Your Ref: OWPC17770
Our Ref: FG/202/17/PL 15-12-2017
Please ask for:
Ross Leal

Change of use from restaurant (A3 Restaurant) to takeaway (A5 Hot Food Takeaway),
repositioning of extraction flue, removal of existing rear extensions, erection of rear
extension for 1 No. flat.

104 Ferring Street Ferring

Proposed Roof Plan

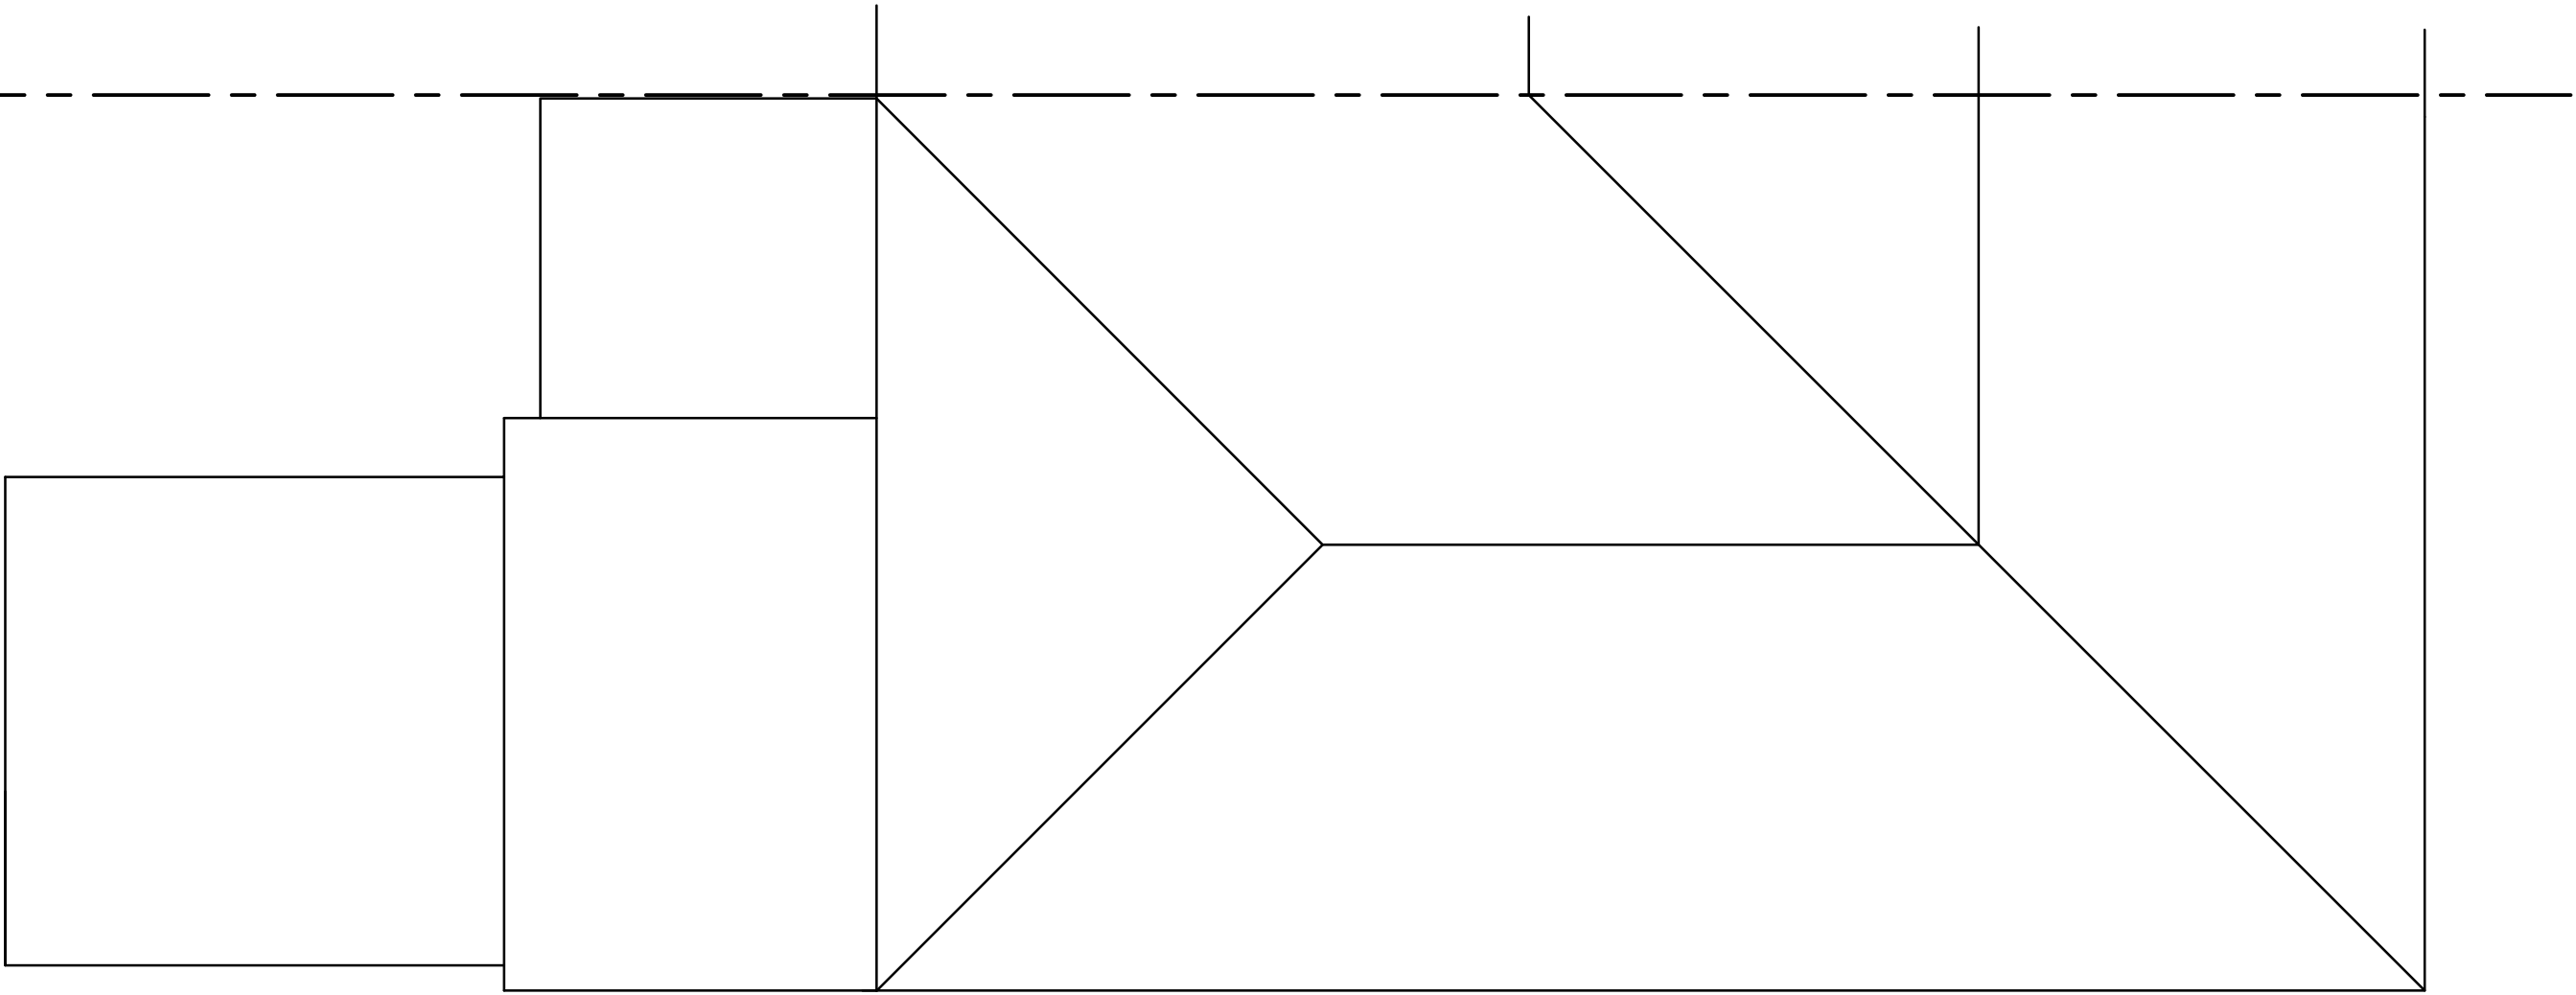
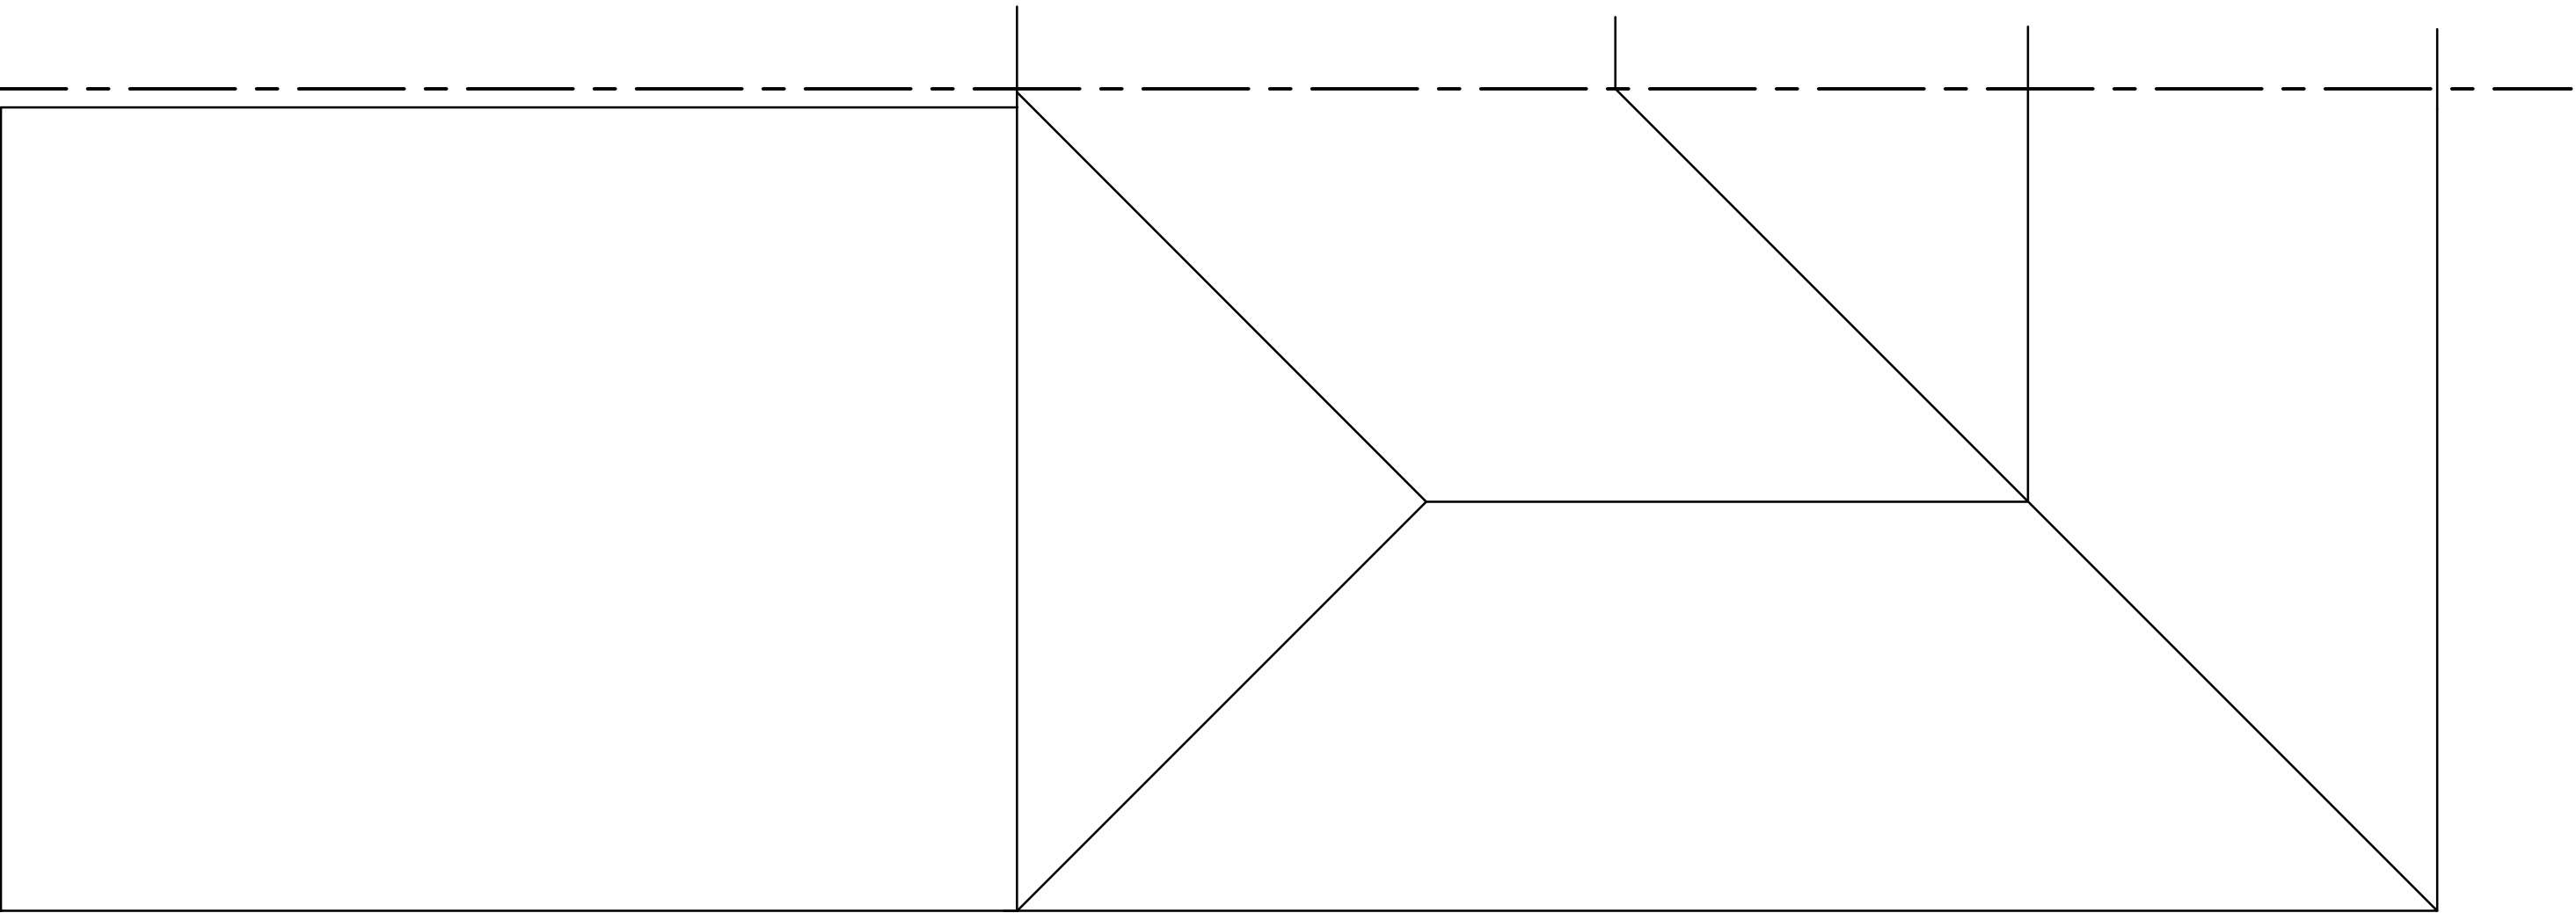
*The proposed flue extension has no measurements on the application?
The drawing shows the original flue extraction assembly as a lot smaller than it actually is.
Therefore i am concerned that the new addition to the flue may be of an industrial style
and unsightly for this location.*
